CITY OF ALBUQUERQUE

June 22, 2021

**Re: Lot 18 Block 38 Volcano Cliffs Subd. SAD 228
6636 Sujeto Rd NW
Grading & Drainage Plan
Engineer's Stamp dated: 4-28-19 (D10D003K15)
Revised for pool Date: 4-28-19**

**Lots 15, Block 5, Volcano Cliffs Subdivision, Unit 18
6636 Sujeto Road, NW, POOL/SPA ADDITION
GRADING PLAN**

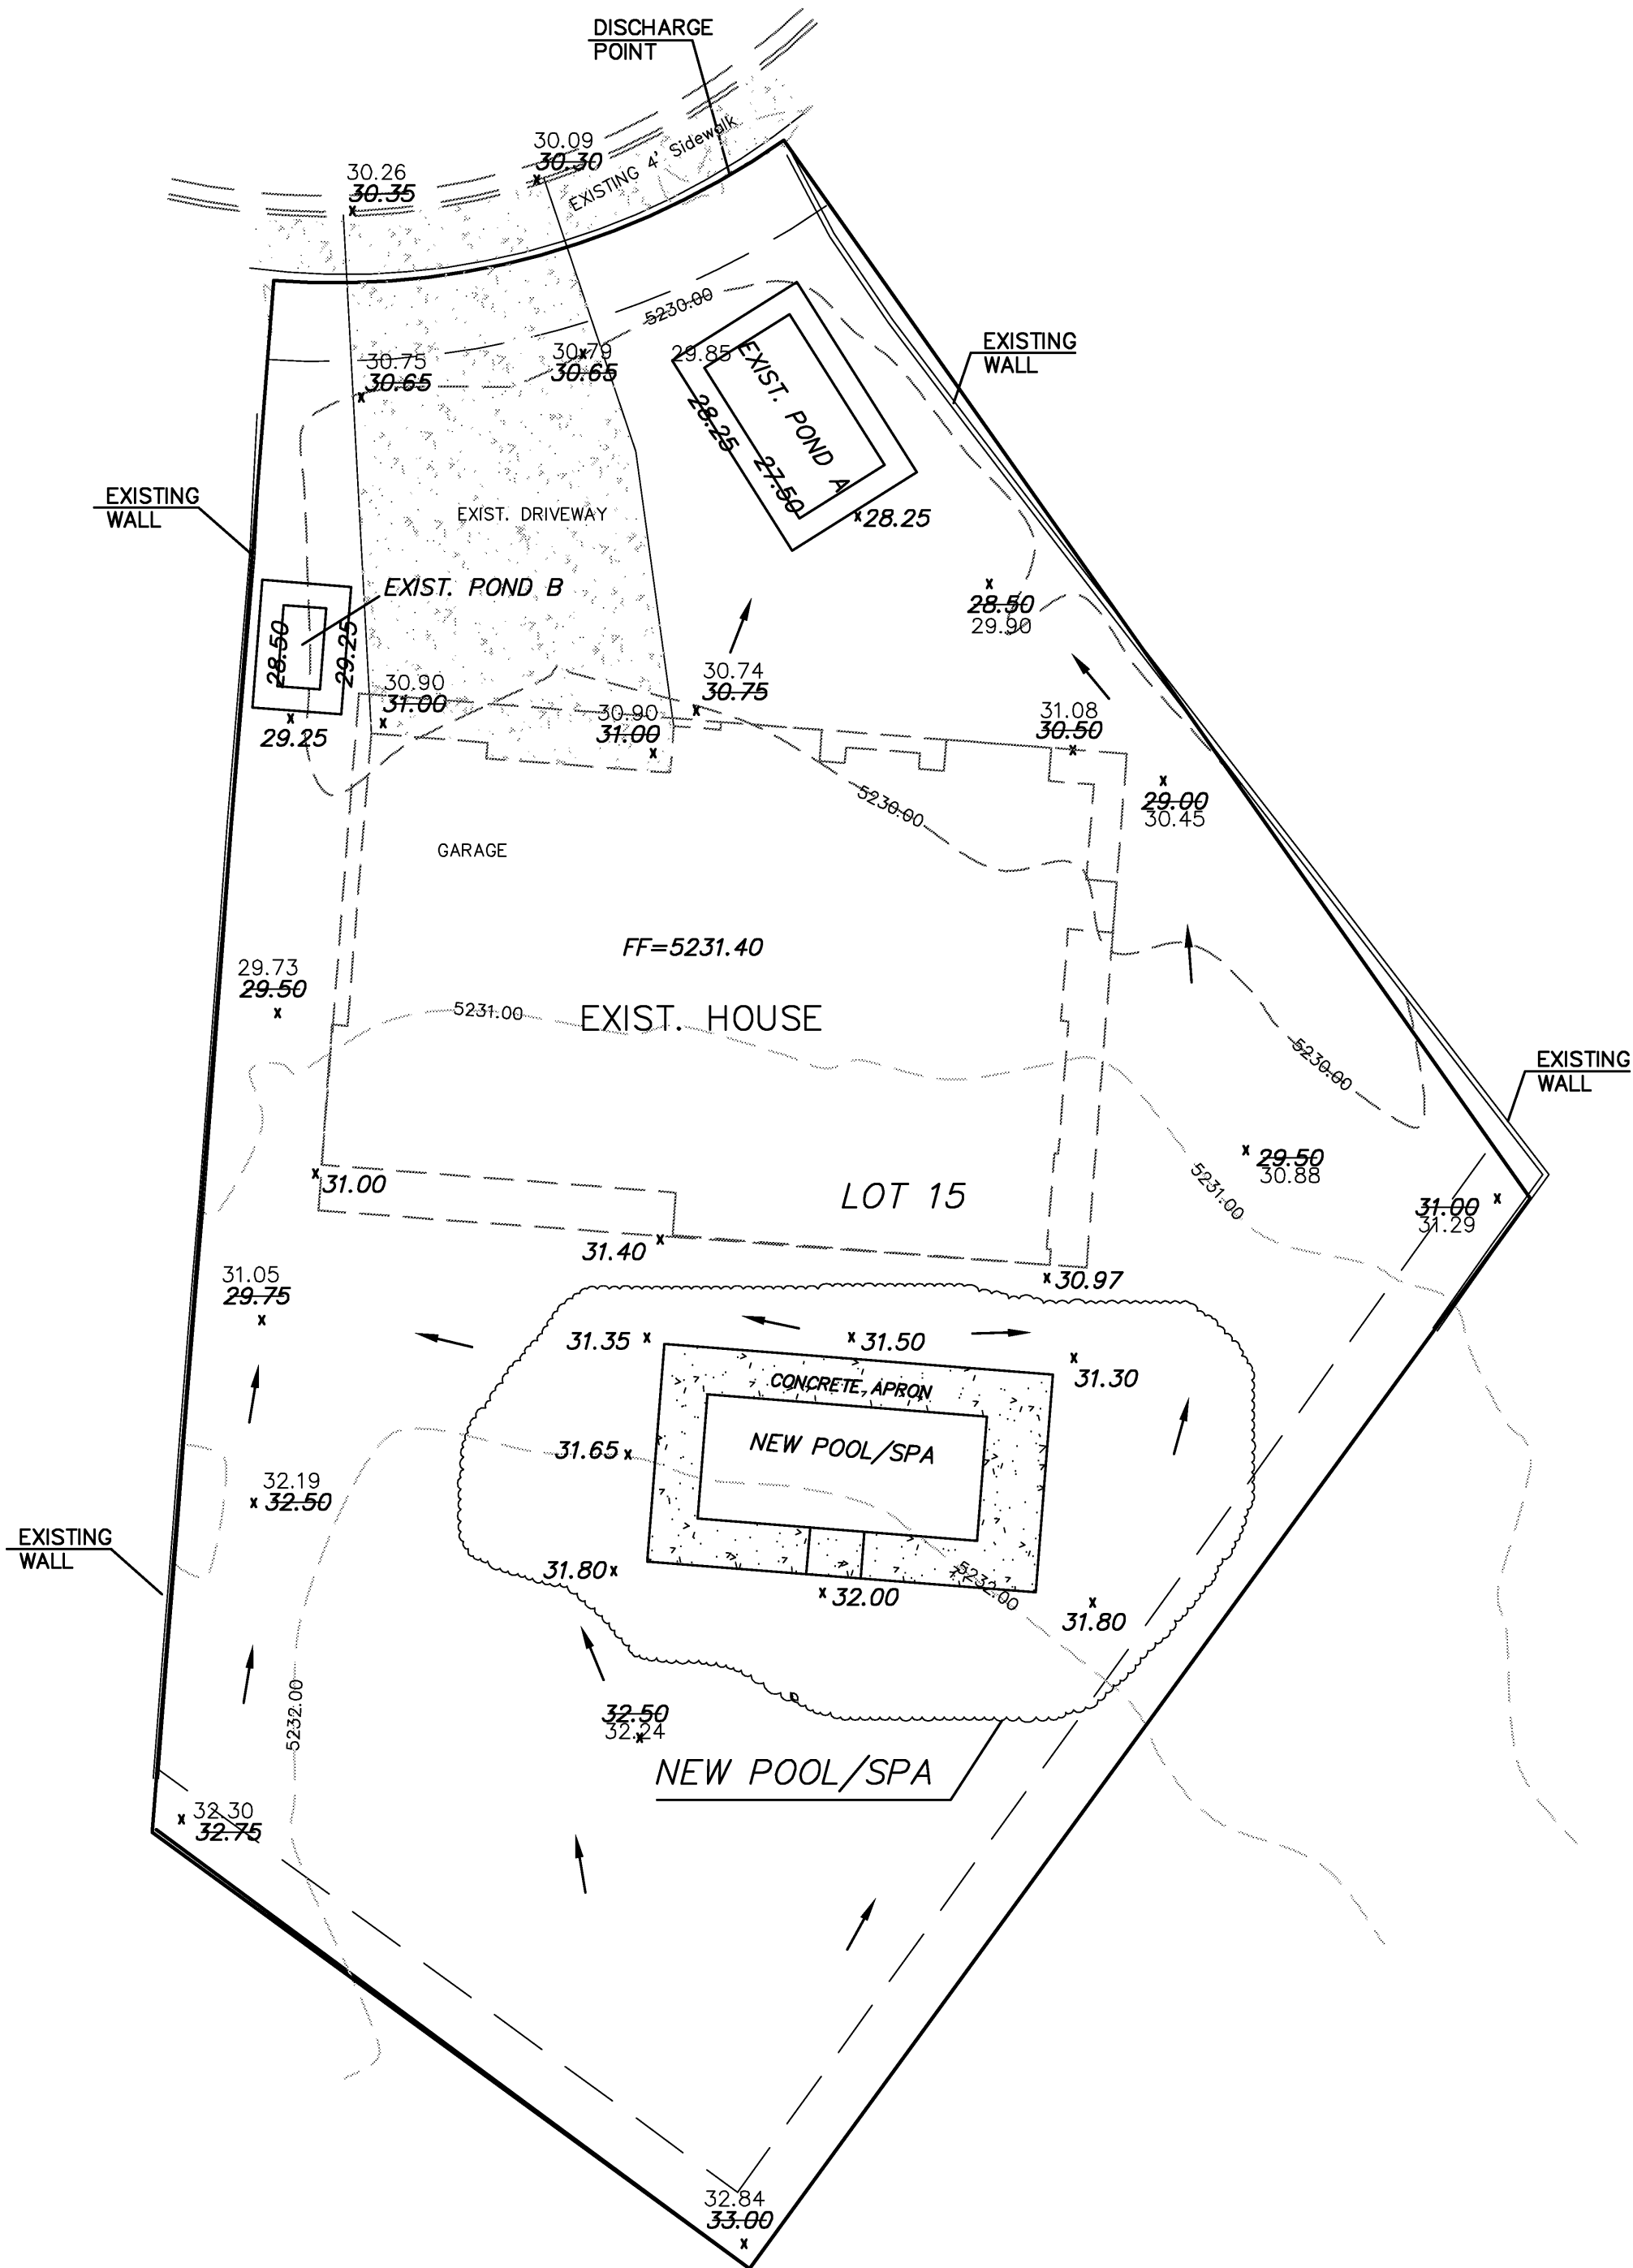
- The approval date is the same as the original approved date. Provide a new approval date with a note stating the changes.
- Provide the new land treatment amounts in red along with the original land treatments.
